About the application

Application number: 2026/91506	
What is the application for?:	Erection of single storey rear extension and front porch to existing barn/outbui
Address of the site or building:	Land adj, 114, Marsh Lane, Shepley, Huddersfield, HD8 8AS
Postcode:	HD8 8AS

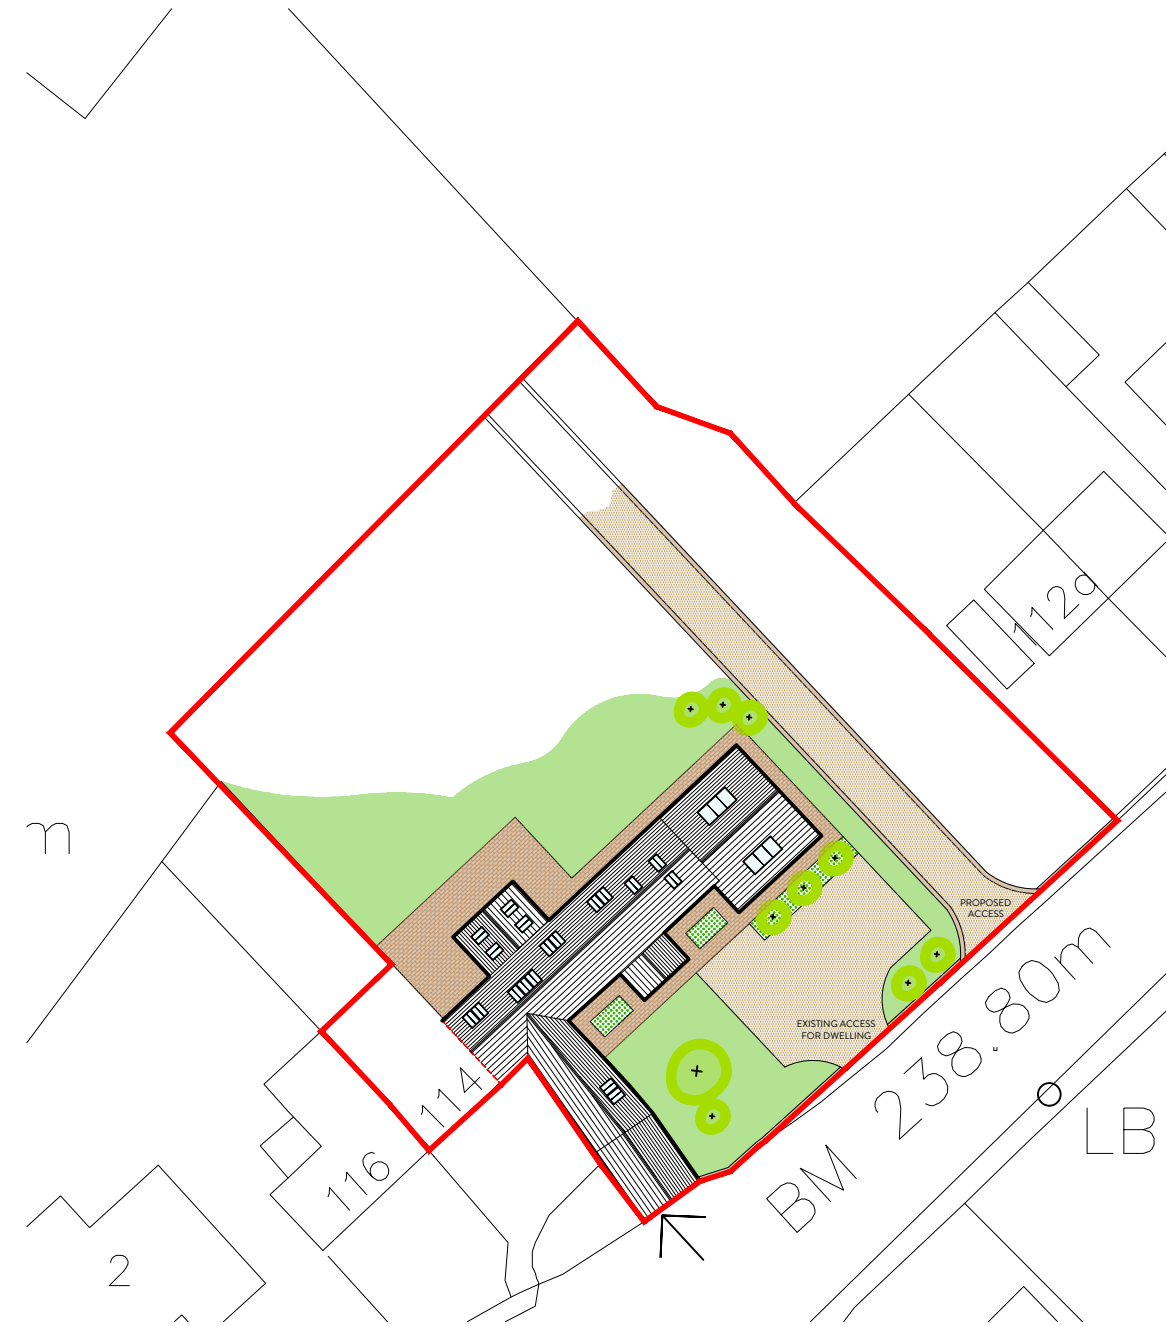
Type of comment: An objection	
Do you wish your comments to be published on the website anonymously?	Yes
We write to object to the proposed planning application for 2026/91506 in its current form, specifically given the relocation of the site entrance to a position directly opposite as this is not fully detailed in the application. Our current objection is based on the following material planning considerations: 1. Accuracy of submitted plans and topography • The topographical information and site context shown are outdated and do not reflect existing neighbouring properties or the newly approved housing development adjacent to the proposed entrance. • We request that the application be revised to include accurate, up-to-date topographic surveys and site plans showing all neighbouring properties, including our own, and the housing development which was designed by the applicant's consultant. This is necessary to enable a fair assessment of impacts. 2. Lack of specific dimensions and siting detail • The application does not clearly show the precise location, orientation, and dimensions of the proposed entrance in relation to our or any other curtilage. • From the information provided, the entrance appears to be sited directly opposite our lounge window and primary living spaces. Clear, scaled drawings are required to evidence the exact position and relationship to our property. 3. Residential amenity: privacy and light glare • Placing the entrance opposite our driveway, garden, and front facing living room windows (as it looks to appear) would potentially result in an loss of privacy, with vehicles passing immediately in front of our primary habitable rooms. • We are currently worried about potential headlight glare from vehicles entering and exiting along a new elongated access route, which would shine directly into our living spaces for extended periods, particularly during darker hours. • Currently, vehicles drive around the existing structure to the entrance/exit, this means there is no direct path to a neighbouring property. • The proposed access would presumably form the main entrance/exit to the property, for agricultural machinery for the farm the property is located on, and also for convenience

- Accurate, up-to-date topographical and contextual information.
- Clear, scaled drawings showing the exact location, dimensions, and alignment of the proposed entrance relative to all other neighbouring properties.
- An assessment of residential amenity impacts (privacy, glare, noise) and a proportionate highway safety appraisal addressing interaction with the new Marsh Lane housing development and on-street parking.
- Clarification as to whether the proposed planning application is anticipated to generate additional traffic movements entering the property/ Marsh Farm through the proposed access point, and, if so, the extent of any projected increase.

We also note that the appointed design consultancy is closely familiar with the immediate context, having designed the neighbouring housing development (approved under 2024/91202) opposite the farm. The omission of our property, and the new development from the submitted plans is therefore of particular concern and should be rectified to allow a transparent and accurate assessment.
